Our Ref: AB/73/18/PL

**Town & Country Planning Act 1990 (as amended)
Town and Country Planning (Development Management Procedure) (England) Order 2015
Application for Planning Permission**

Development	Demolition of garage & erection of two dwellings with associated car parking and landscaping
Location	18 Queens Lane Arundel

NORTH ELEVATION - PROPOSED
SCALE 1:100

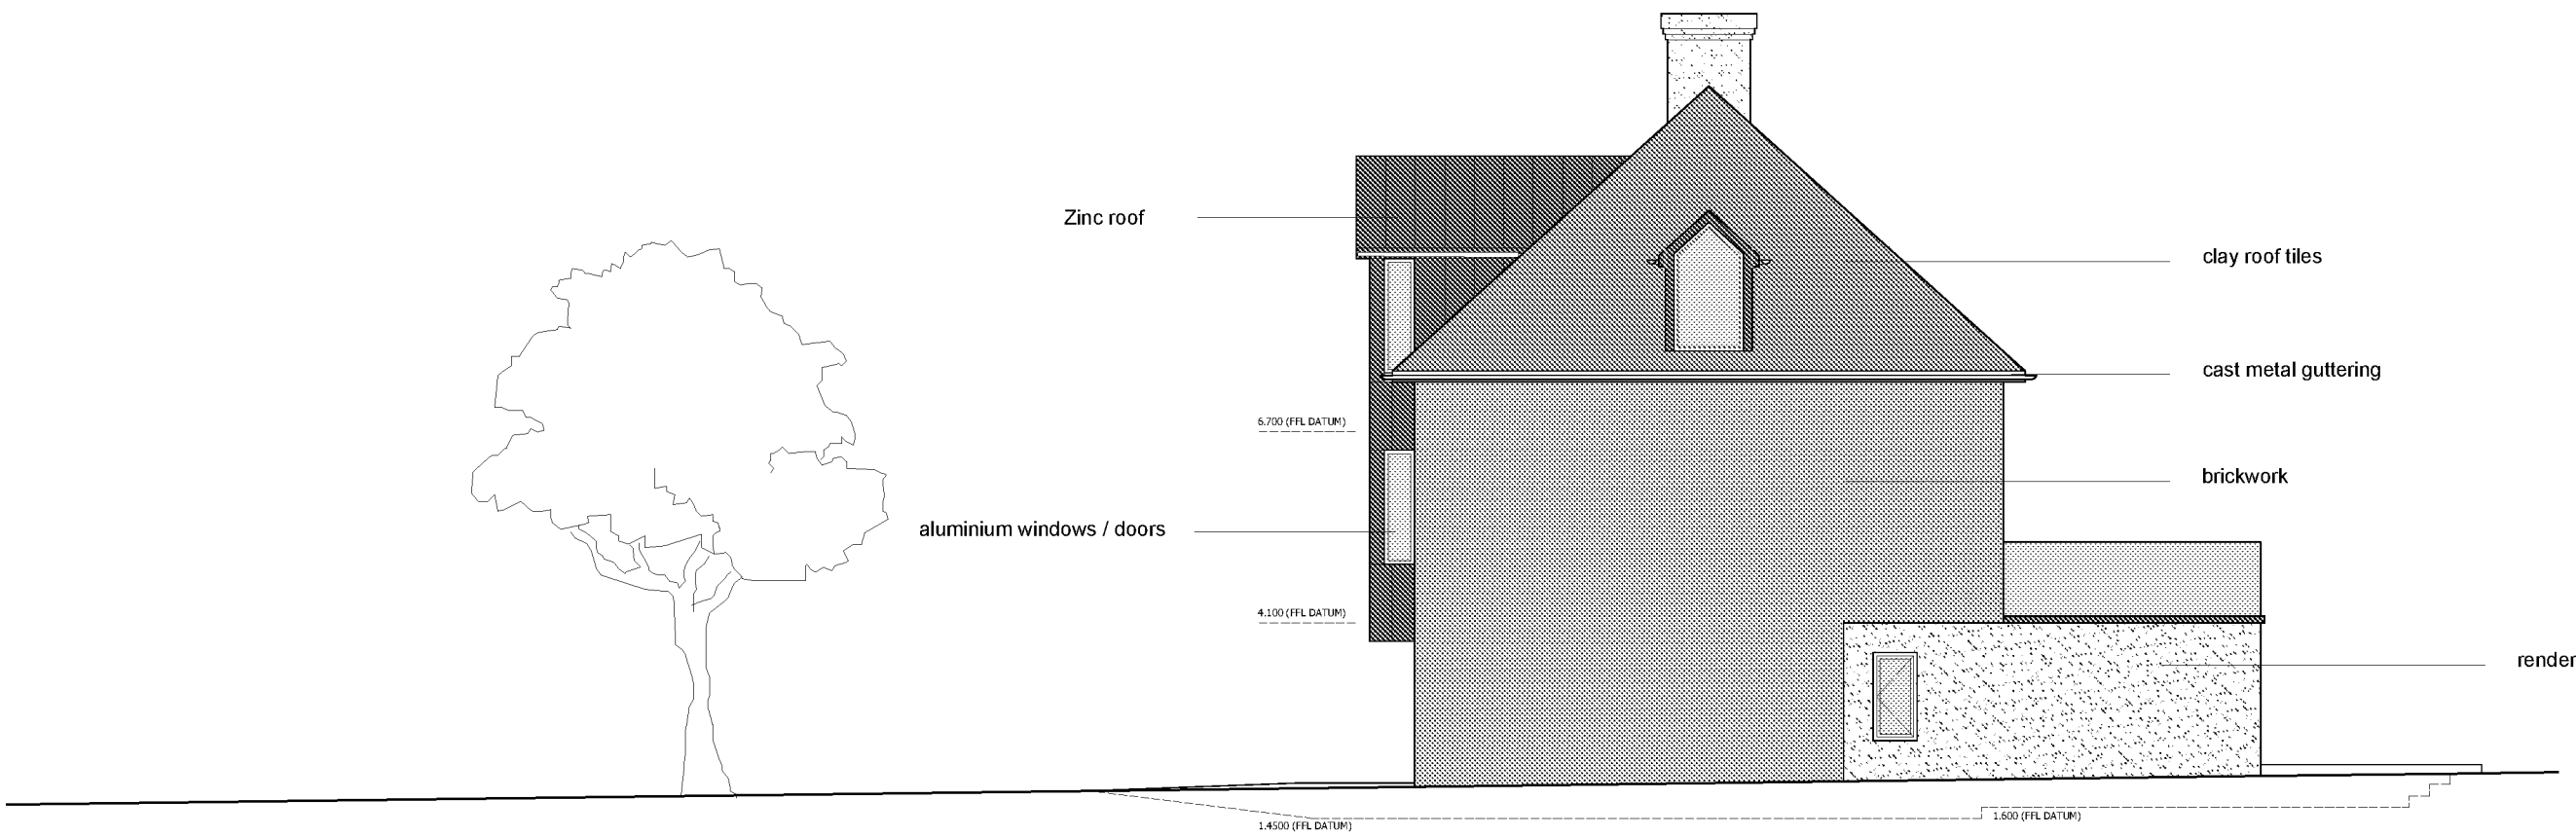
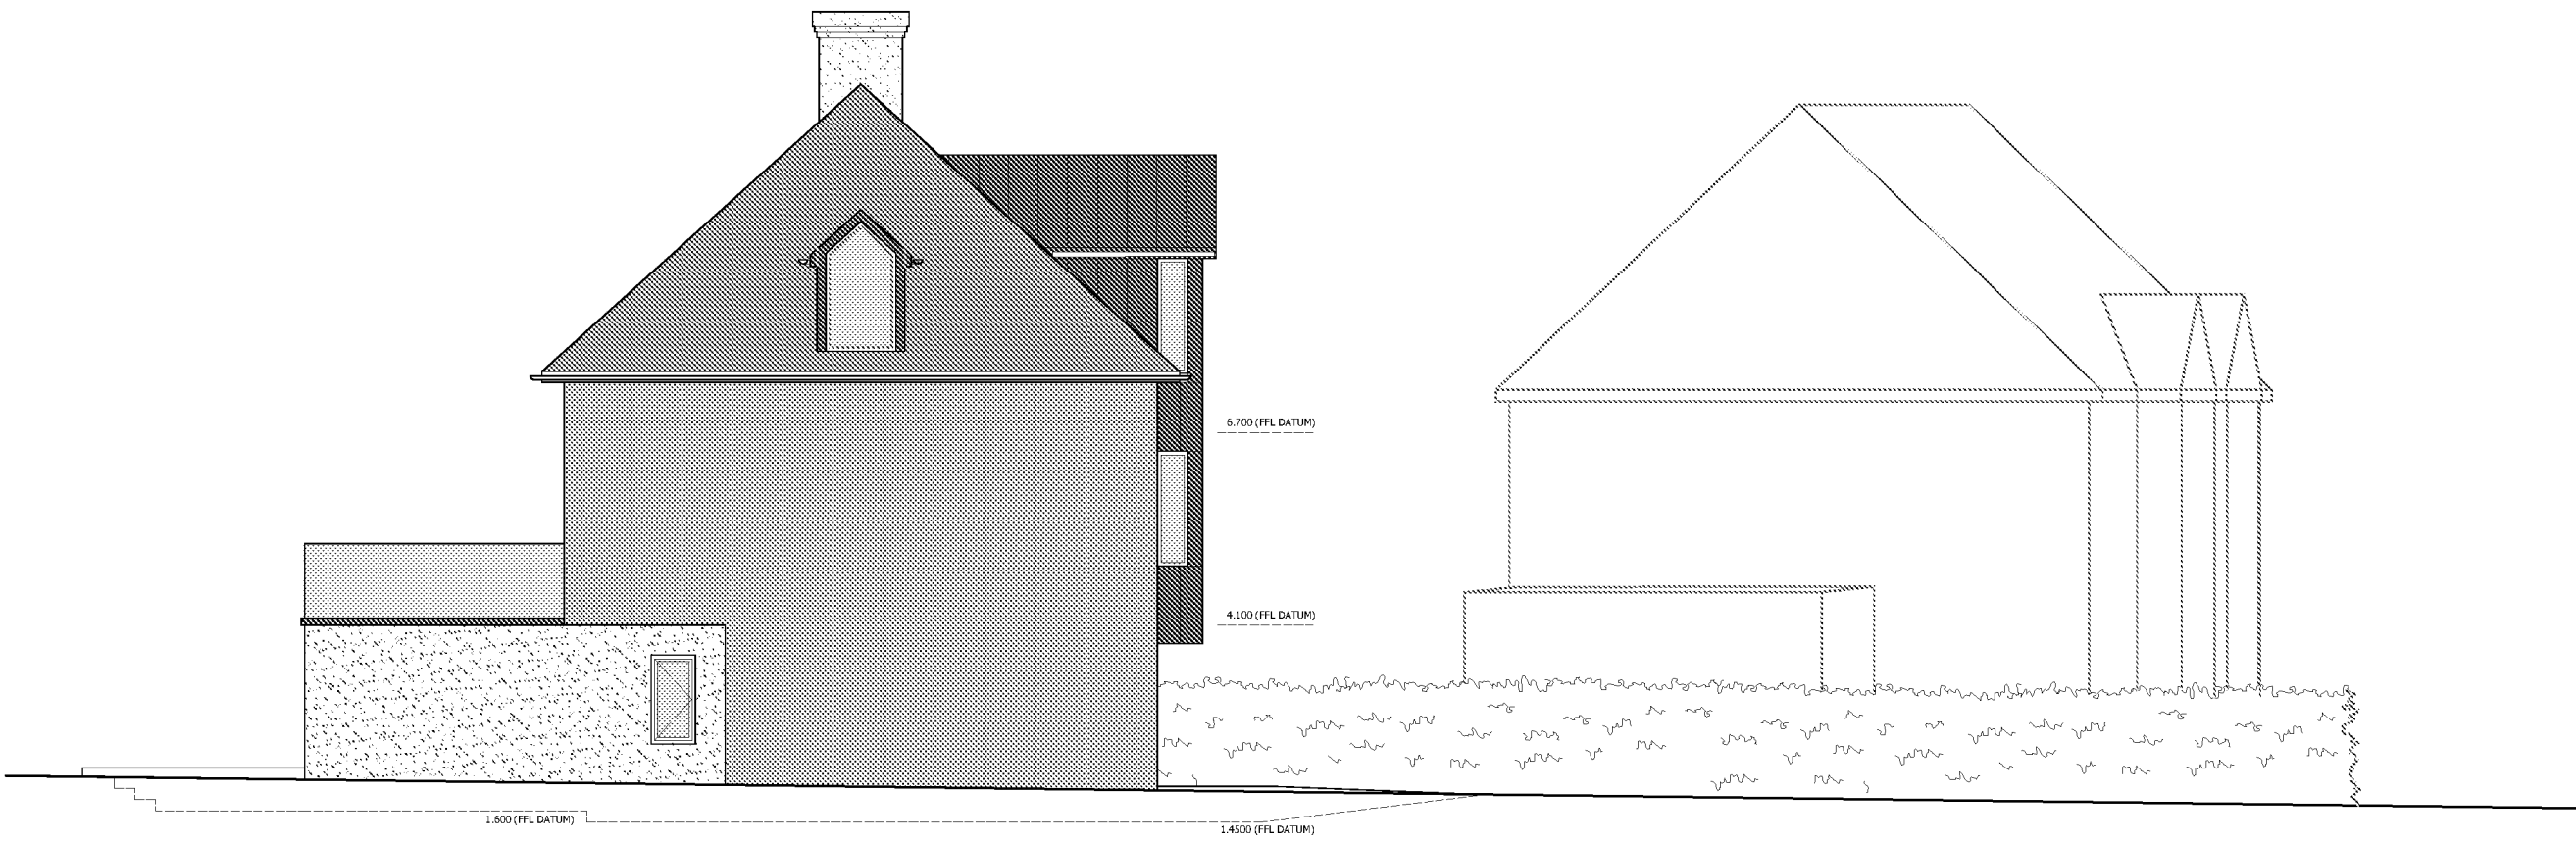
There are small windows indicated on the Proposed North and South elevation that have not been indicated on the proposed floor plans. Please amend accordingly.
